**Fwd: 415 Cumberland Ave.**

From: **Barry Yudaken** <yudaken@archetypepa.com>  
Date: Thu, Mar 29, 2018 at 3:59 PM  
Subject: RE: 415 Cumberland Ave.  
To: Jeanie Bourke <jmb@portlandmaine.gov>, jgrant@portlandmaine.gov

I would like to ask one more question regarding this project, and I don't want to use up your time with a 3<sup>rd</sup> meeting, so I'll ask in this email. I'll attach the plans and elevations to help explain.

**A1.01**

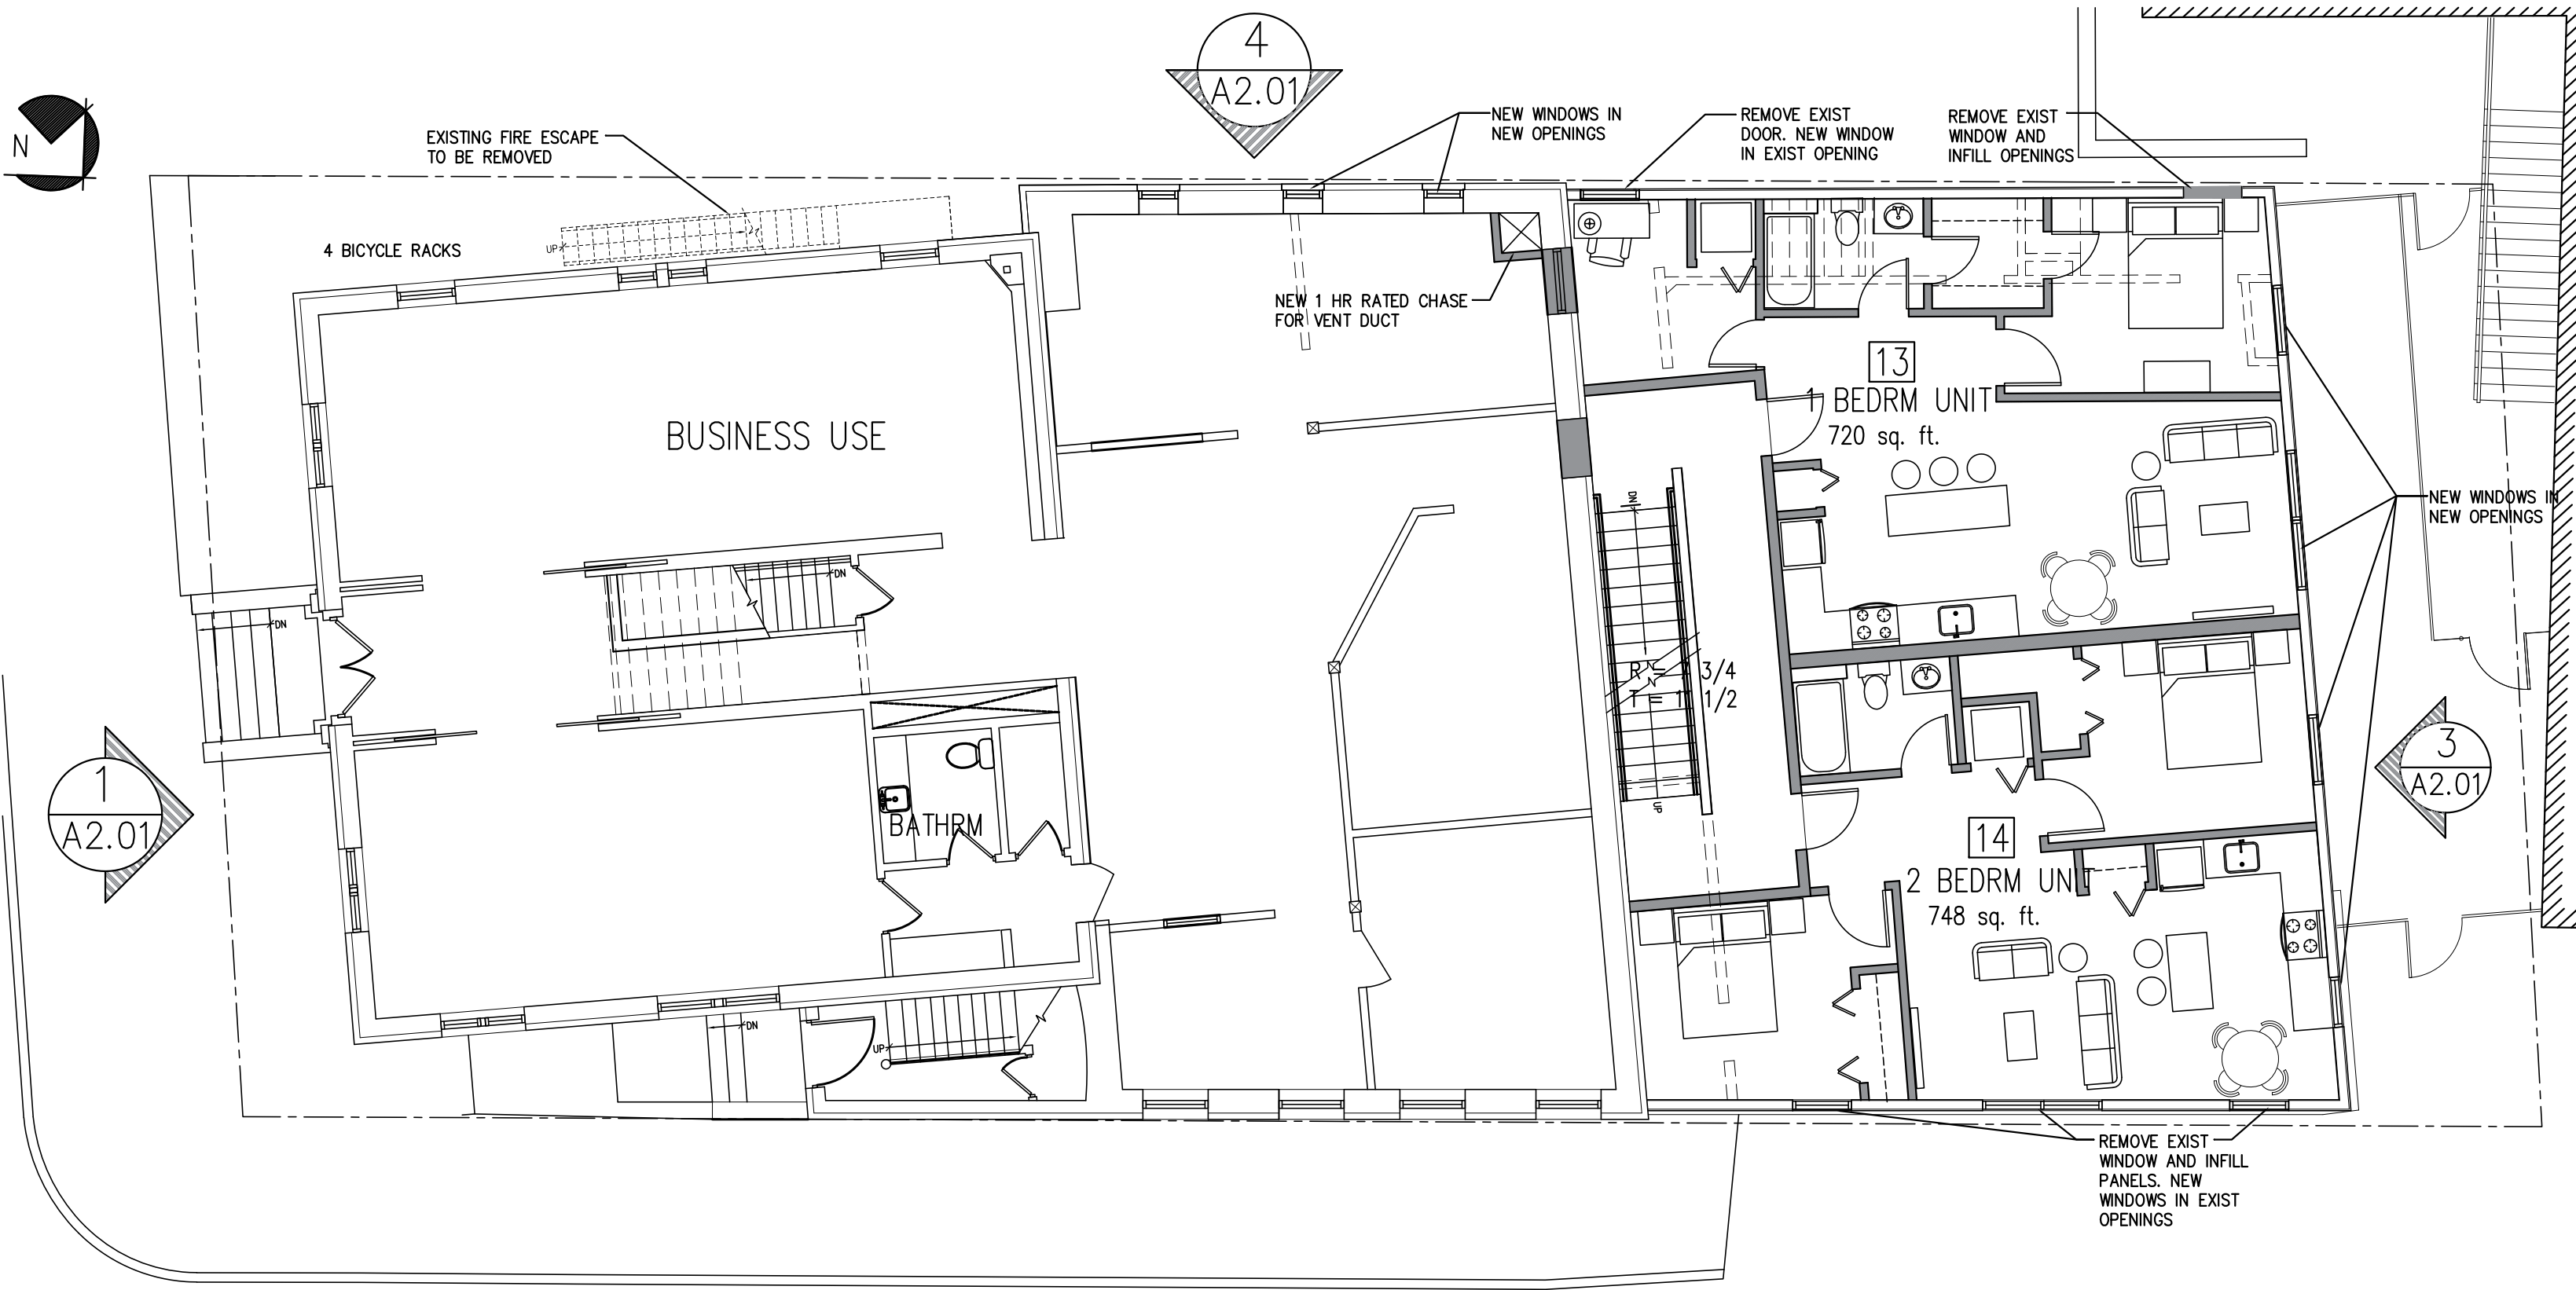
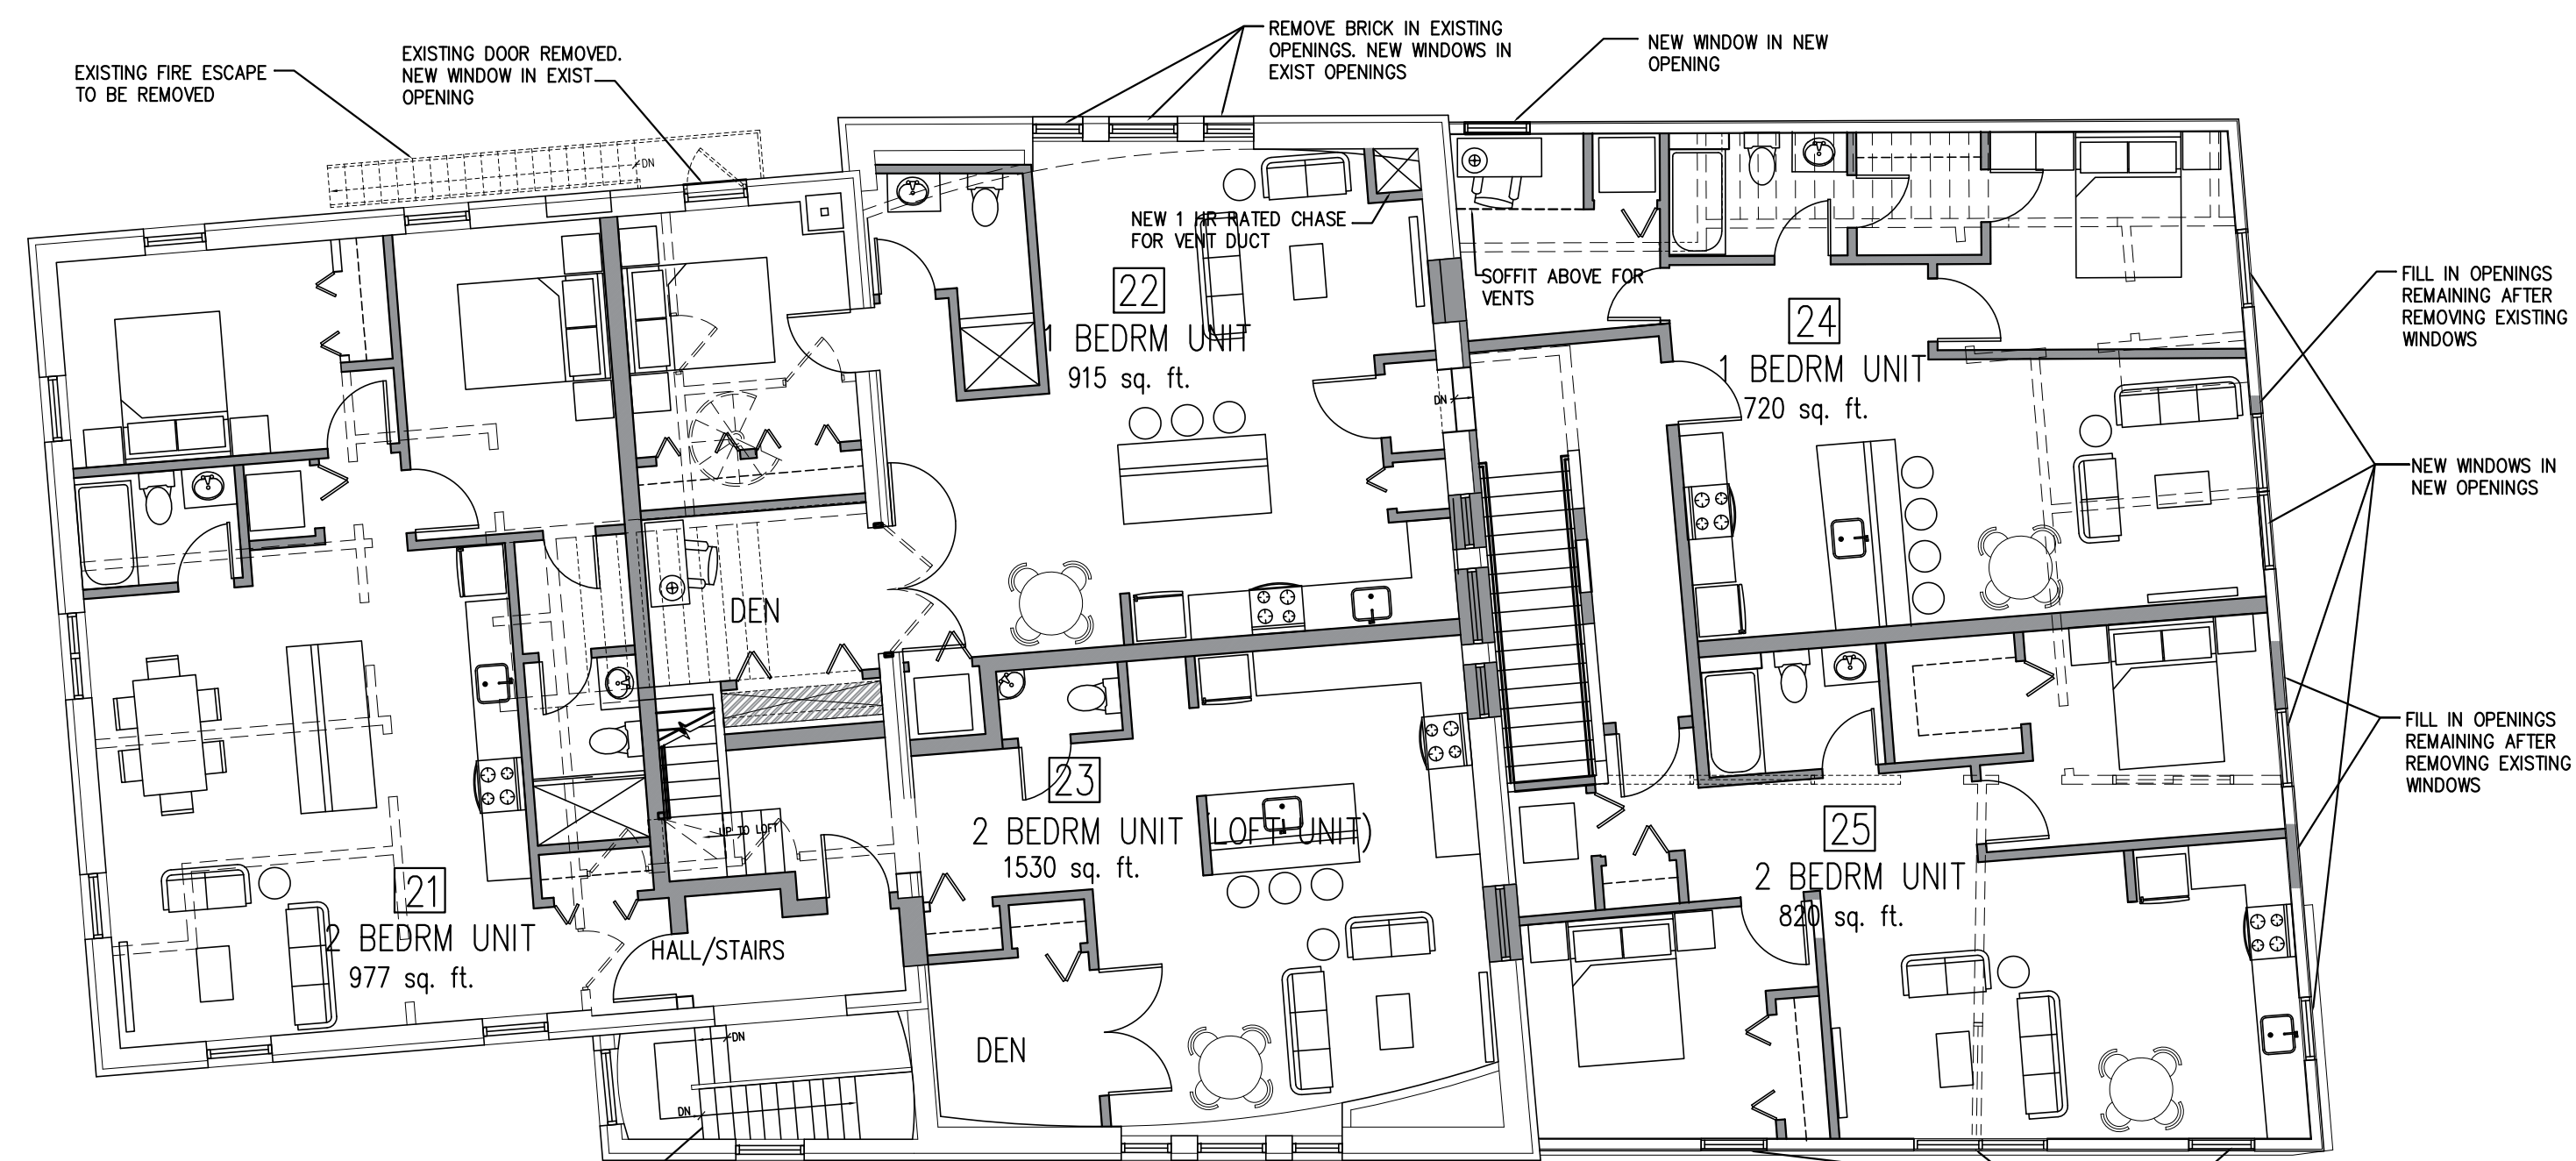
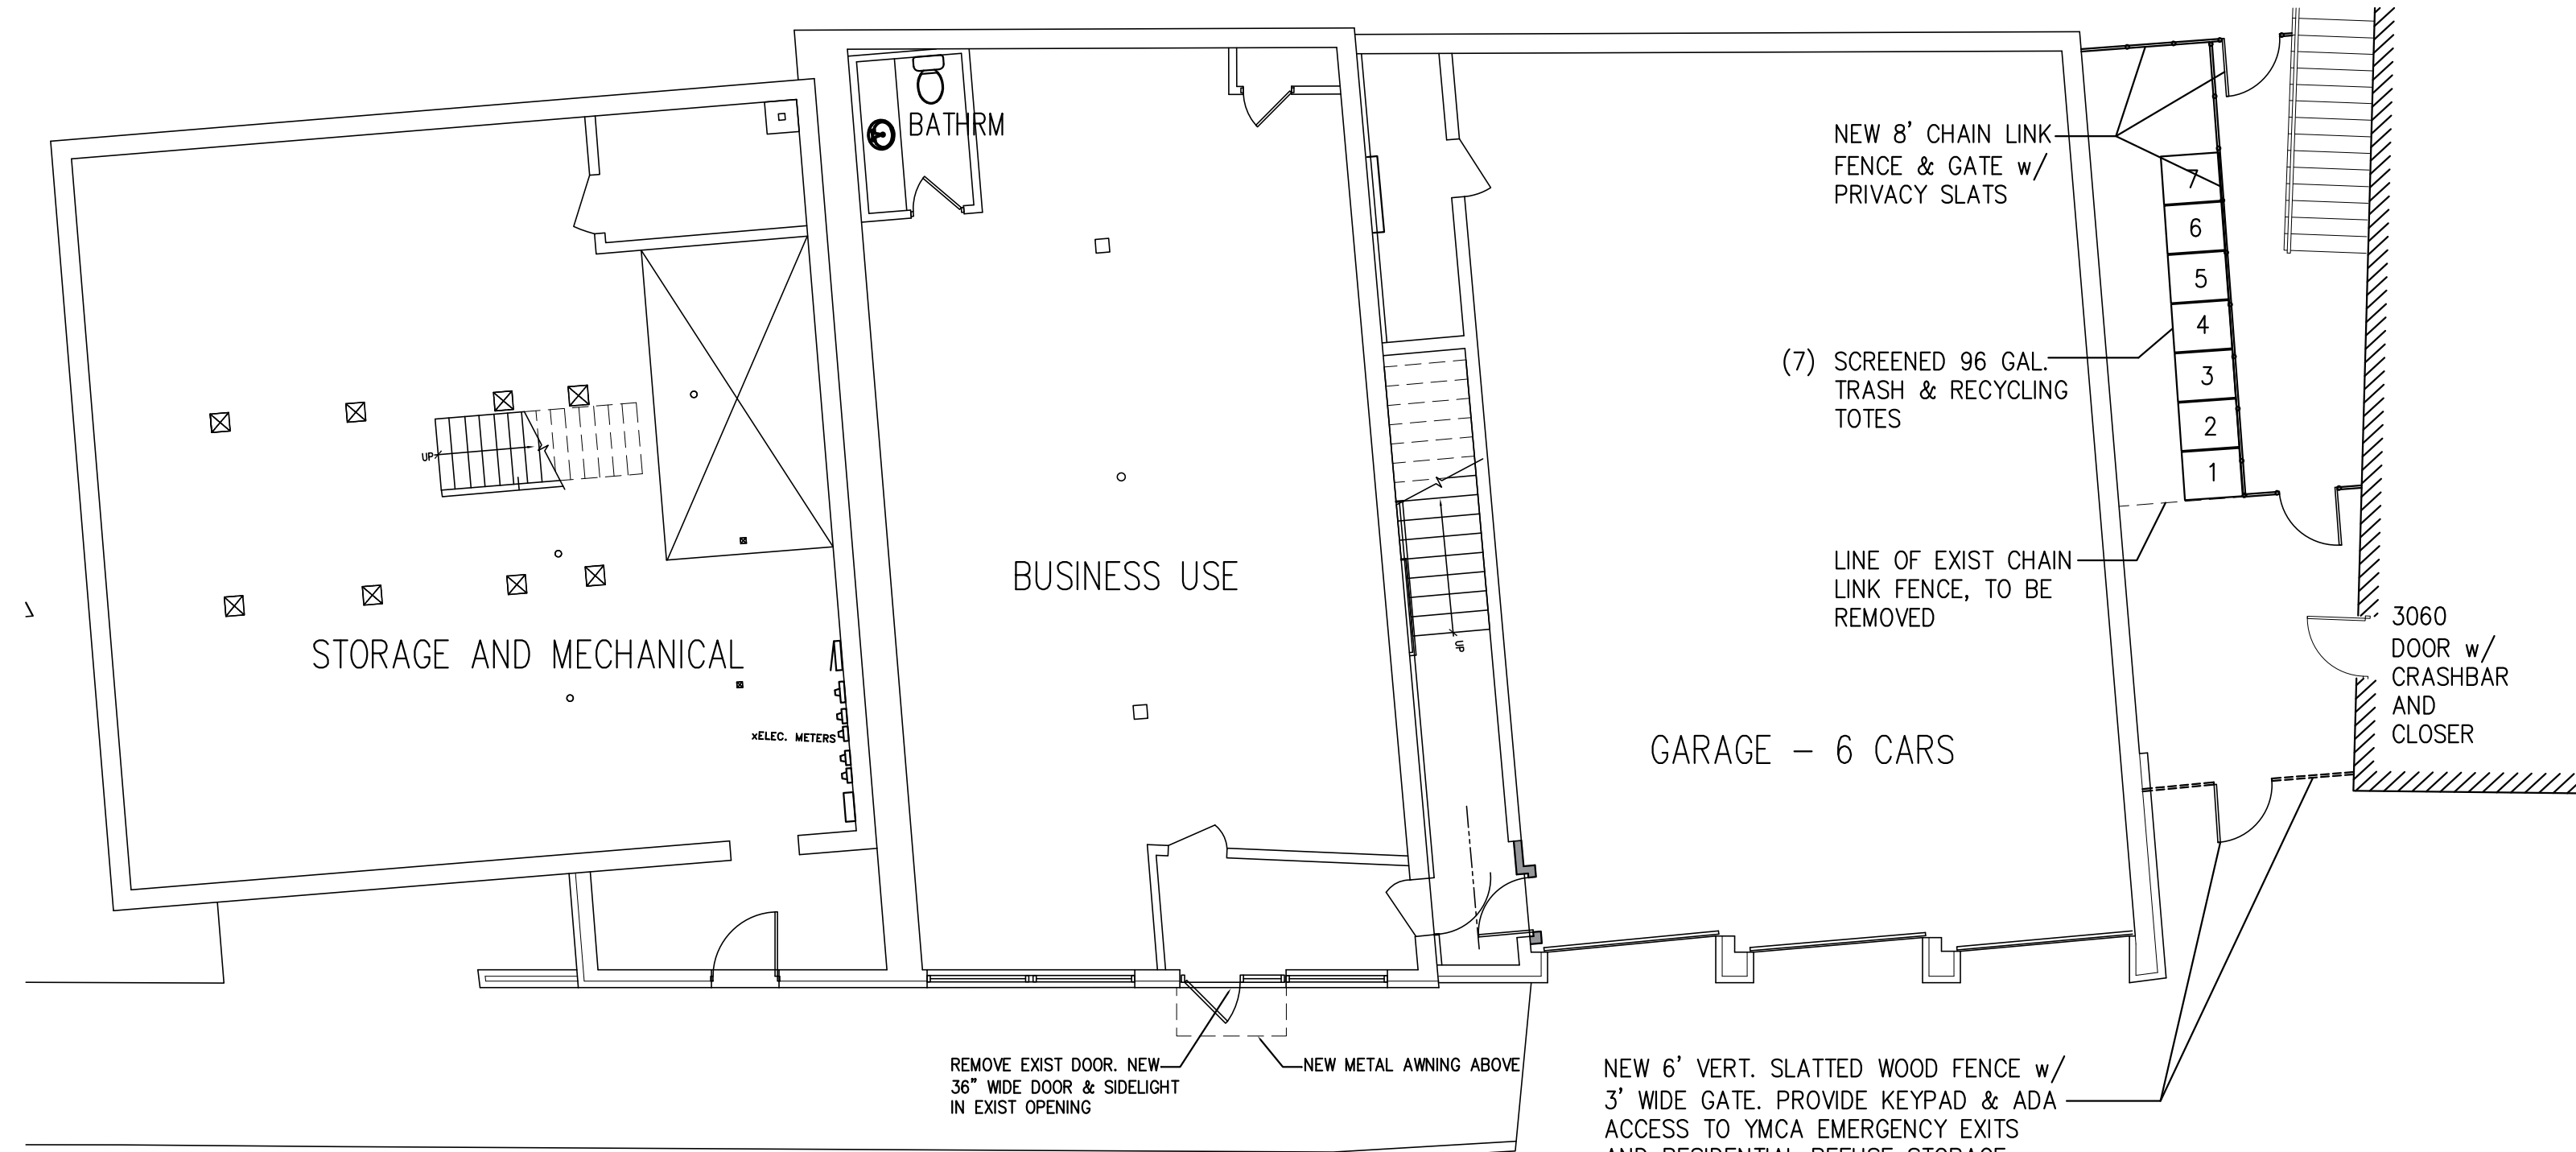
Currently on the plans the 2<sup>nd</sup> floor Unit No. 23 had 2 bedrooms in the 3<sup>rd</sup> floor Attic Penthouse. When I met with you to discuss the issue of One means of Egress, it was pointed out that those bedrooms would need emergency rescue egress. When I suggested the door to the roofdeck it was pointed out that the sleeping rooms themselves had to have the egress and that the dormers should be used. We have shown that on these plans (the dormers altered for bigger openings and a level platform created outside each dormer to wait for rescue).

The owner has just asked me if he can increase the unit count by making the attic penthouse a studio unit with its entrance door on the 2<sup>nd</sup> floor hall/stairs next to Unit 23. Unit 23 would then be redesigned to be a single level one bedroom unit.

The studio unit itself will be the bedroom. Can the door to the roofdeck then be the secondary means of escape? It leads to a flat roof that is right above the street, and probably safer than plucking someone off from the platform we proposed in front of the dormer. Also, we still meet NFPA 2009 30.2.4.4 (excepting that there are more than 4 total units on the 2<sup>nd</sup> floor, but only 3 units using each of the 2 means of egress).
